From: Laura Gibbons
Sent: 20 December 2018 11:56
To: Planning.Responses
Subject: RE: Planning Consultation on Y/92/18/DOC

Engineers Comments Regarding Conditions 8, 9 and 10

APPLICATION NO: Y/92/18/DOC

Site Address: Land at Long Acre Maypole Lane Yapton

Infiltration Test Locations

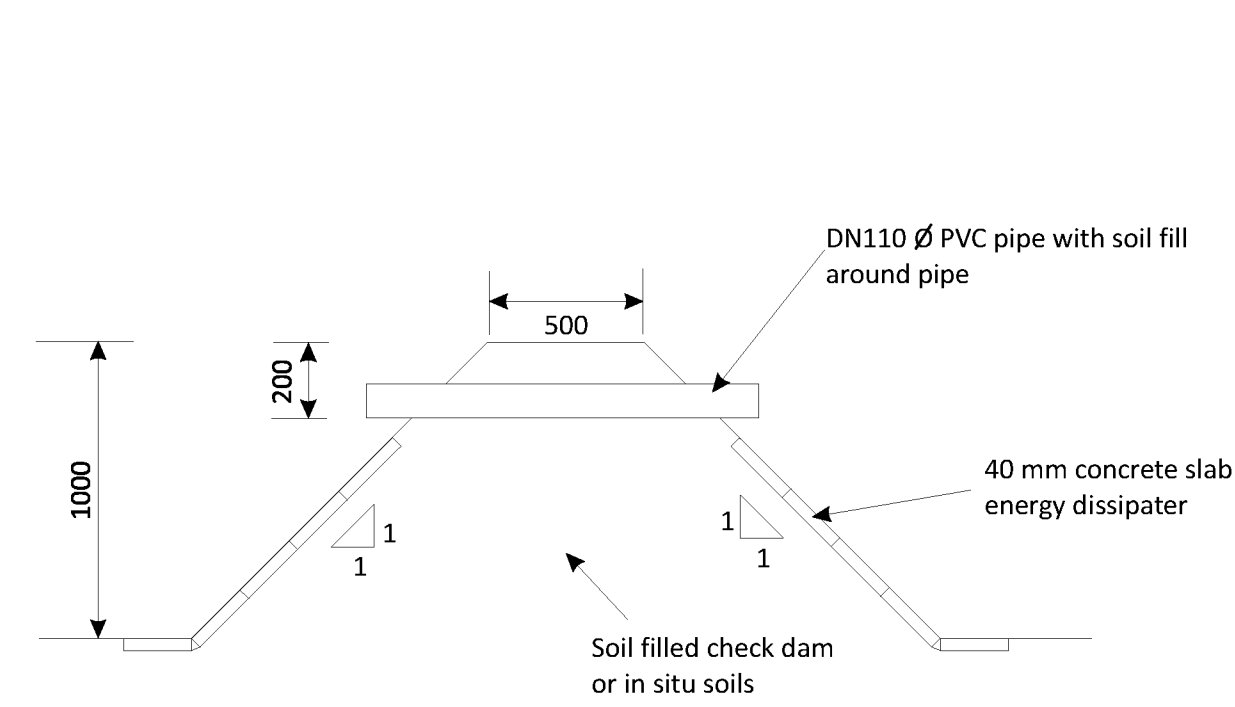
2. Infiltration rates are also better than we would expect in this area. When were the infiltration tests completed? Infiltration testing needs to be completed within the winter. And were three successive tests completed at each location? This will need to occur before condition 8 is approved.

Typical Road and Swale Section
Scale 1 : 25 at A1

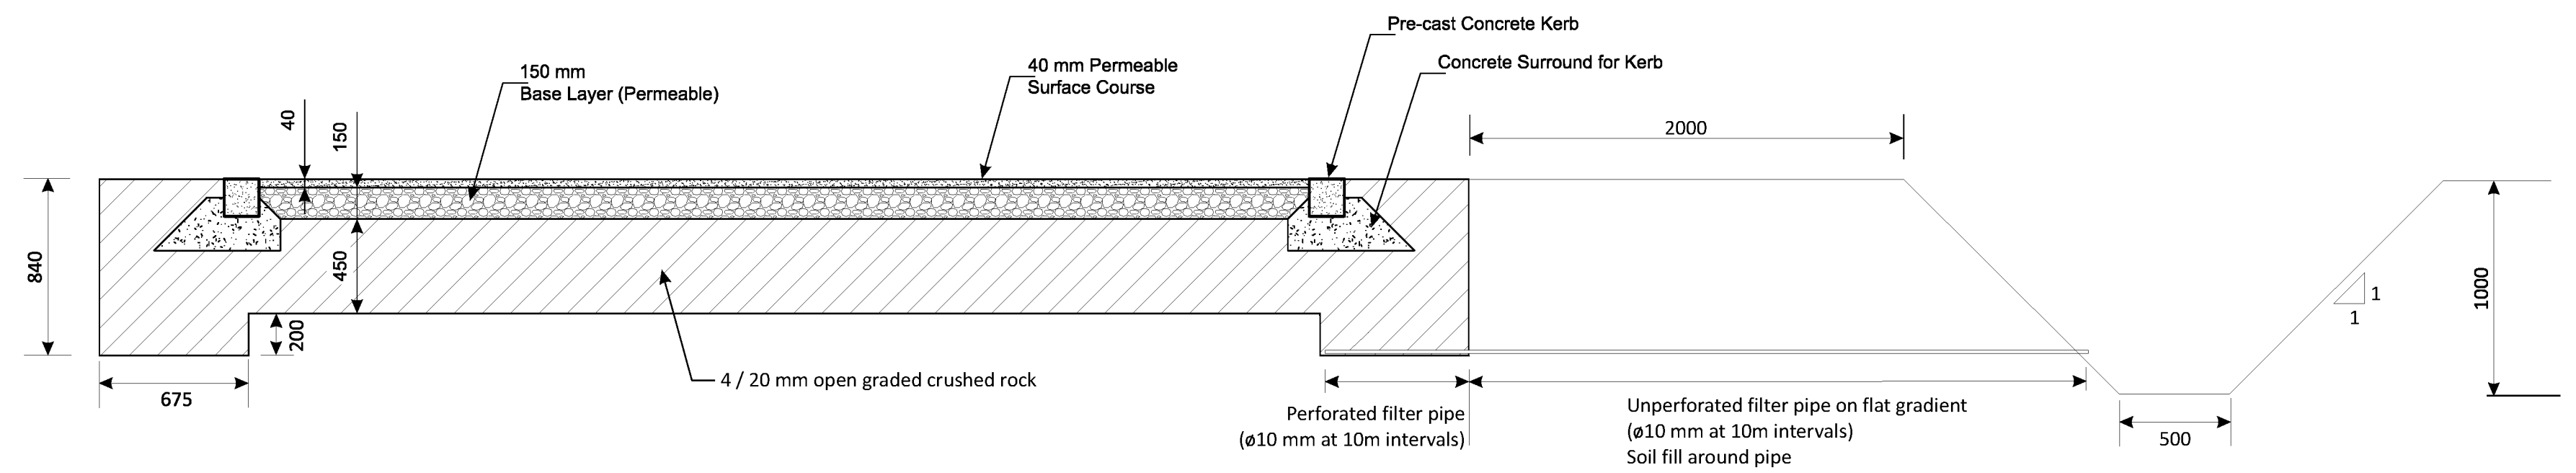
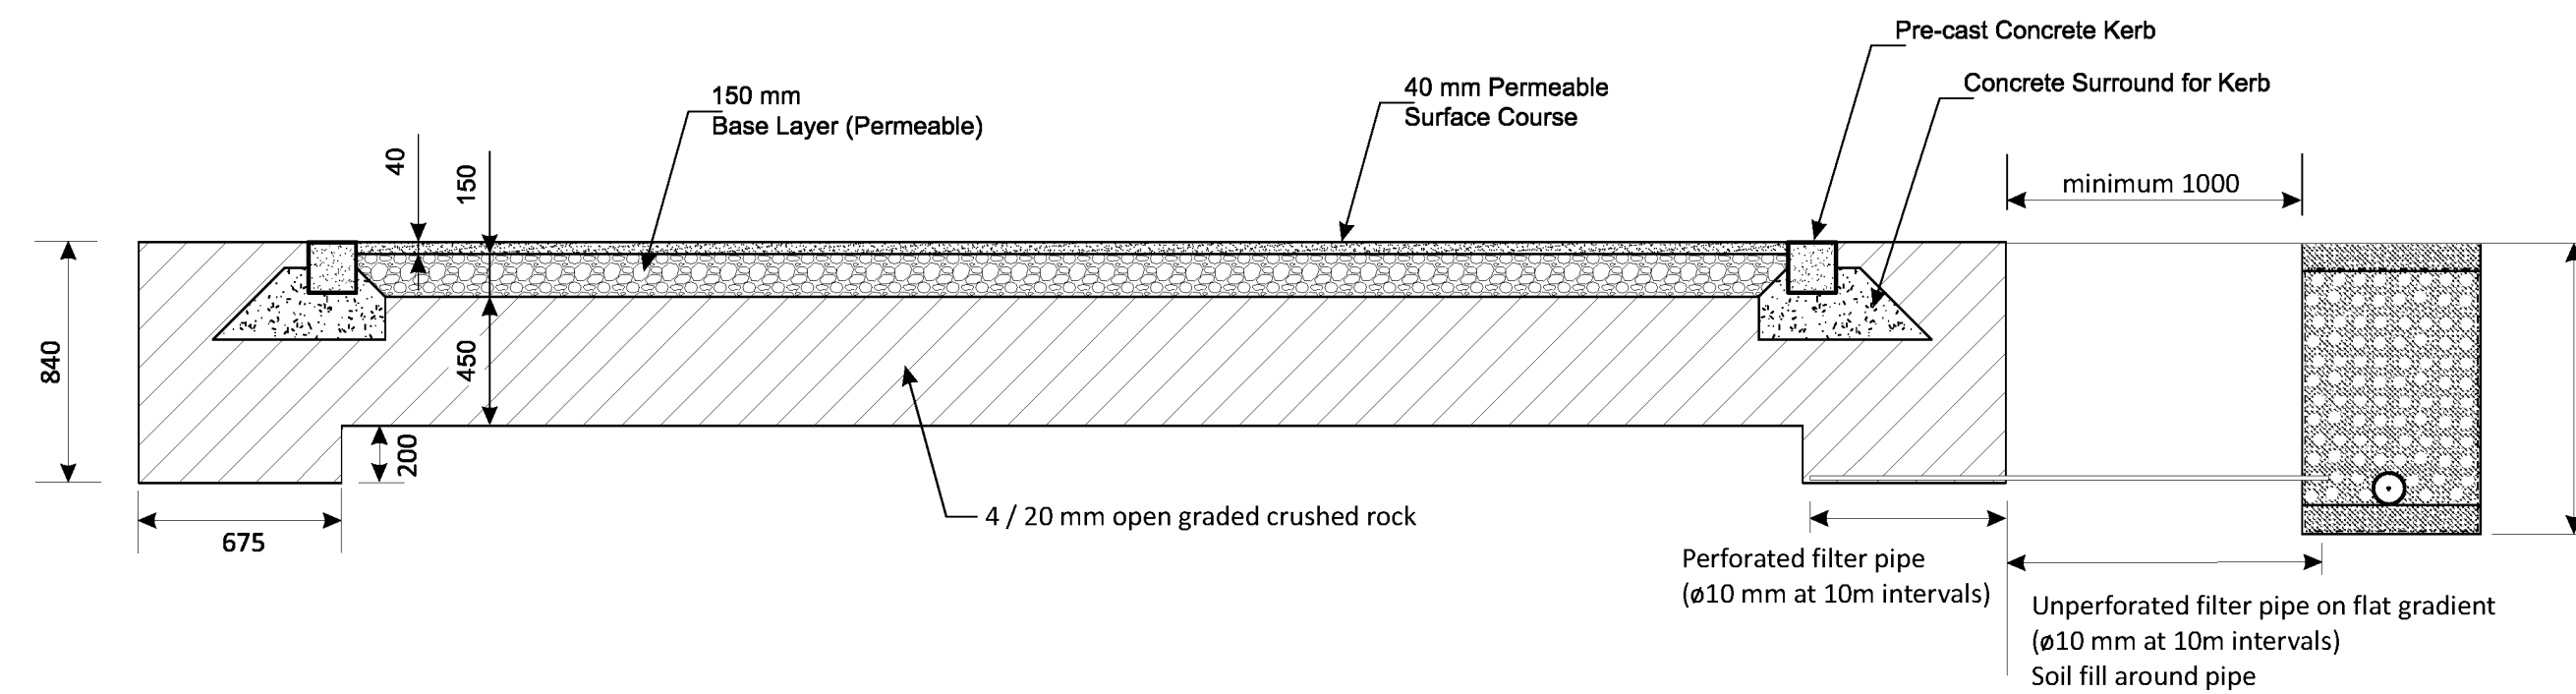
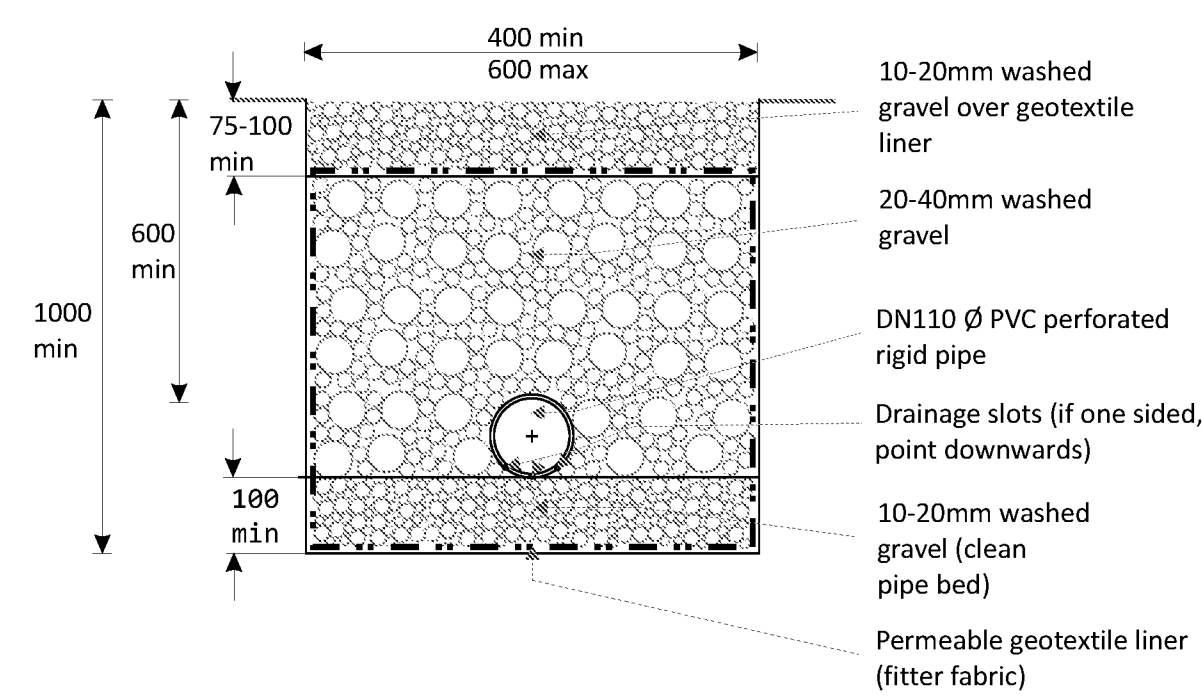
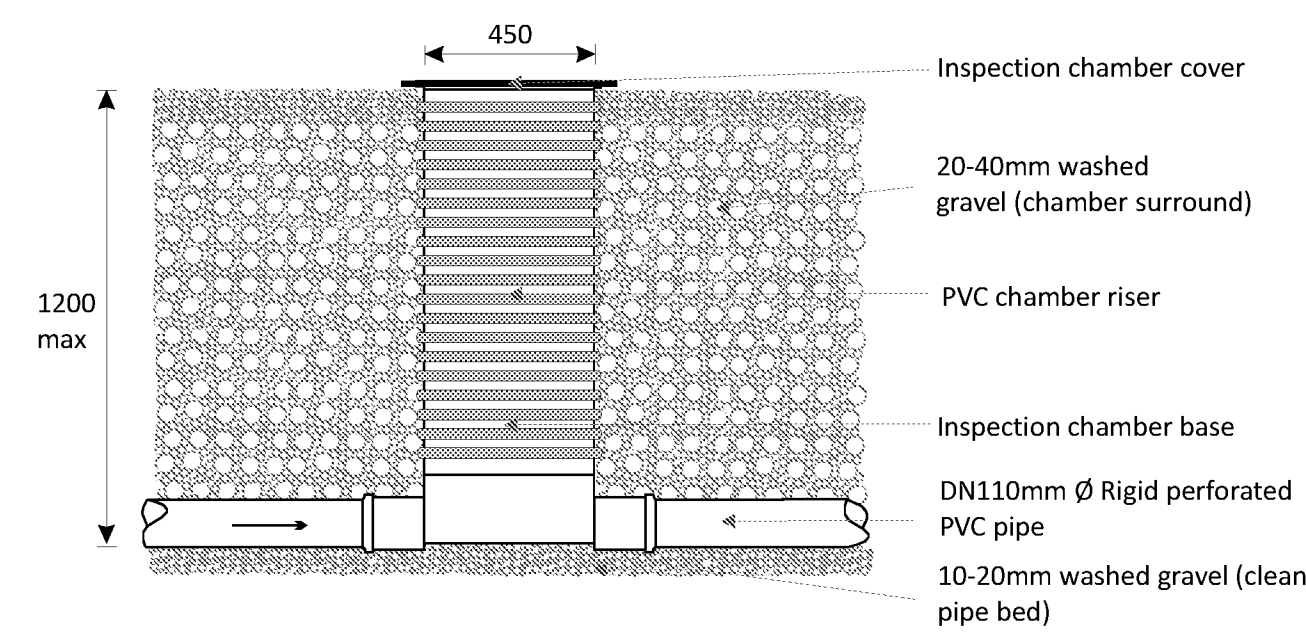
14. Full construction detail drawings will need to be submitted.
15. Land drainage consent has been applied for, but this has not been agreed. Until further details of infiltration testing and monitoring are provided it will be difficult to review this.

Groundwater Monitoring Locations

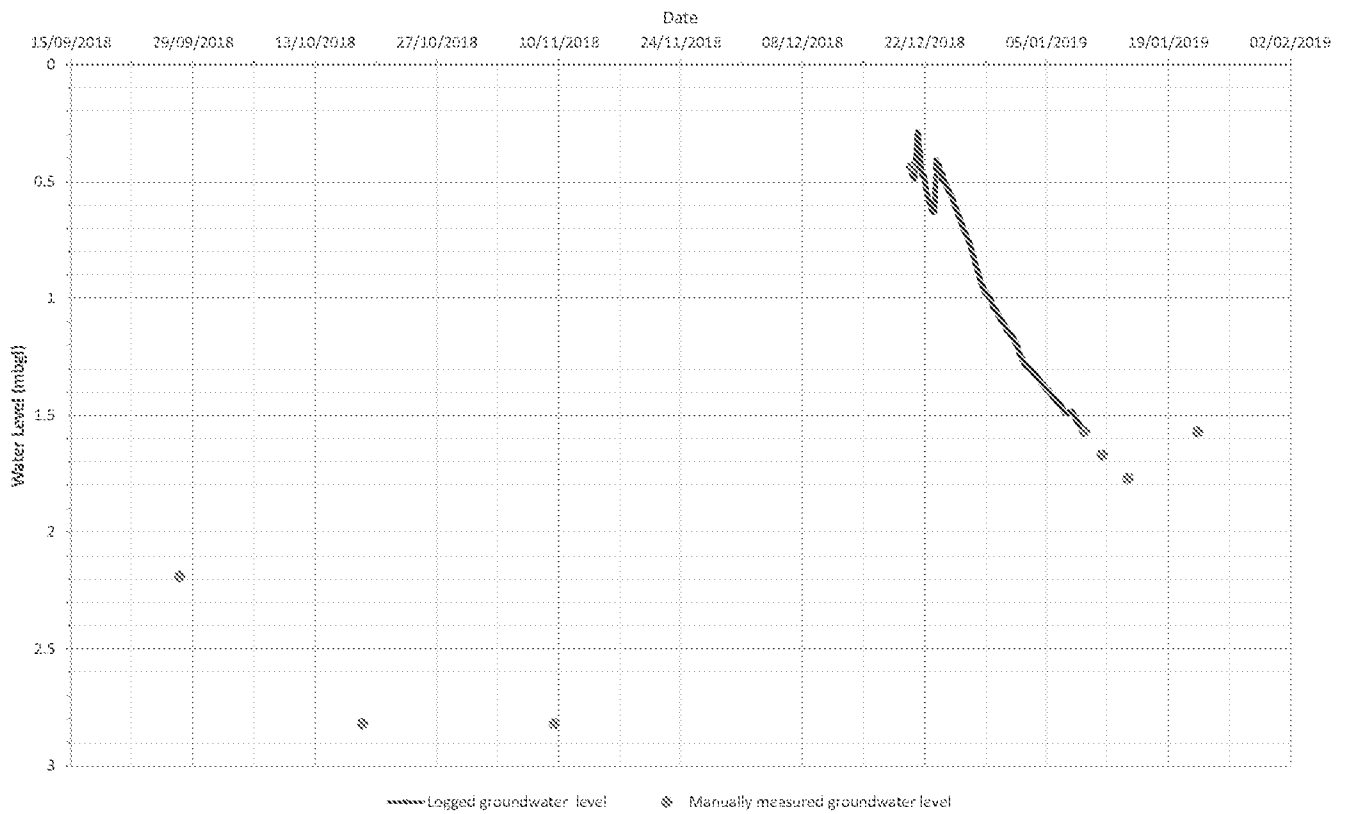
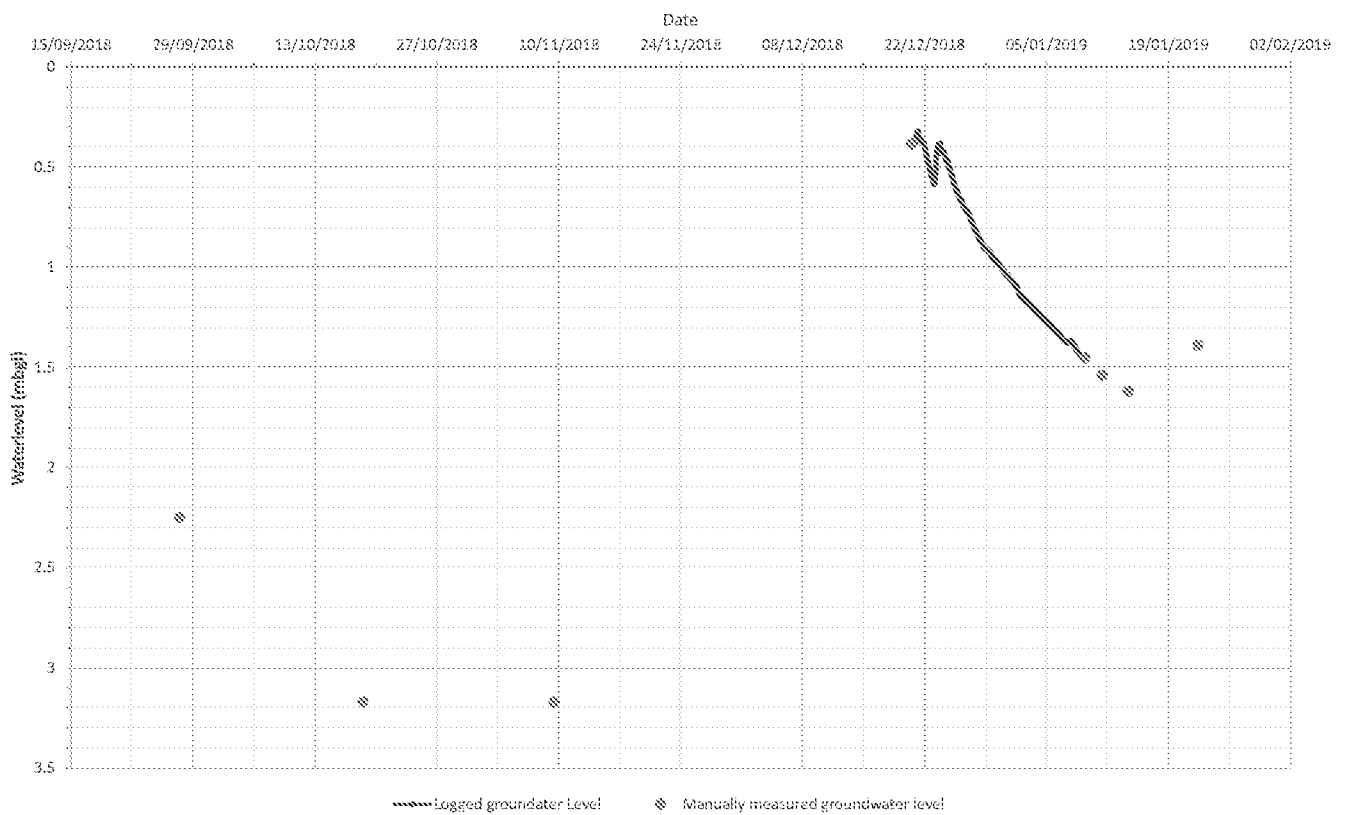
1. Groundwater was found to be a lot lower than we expected, I note that winter monitoring has not occurred at the locations where infiltration is proposed. This will need to occur before condition 8 is approved.
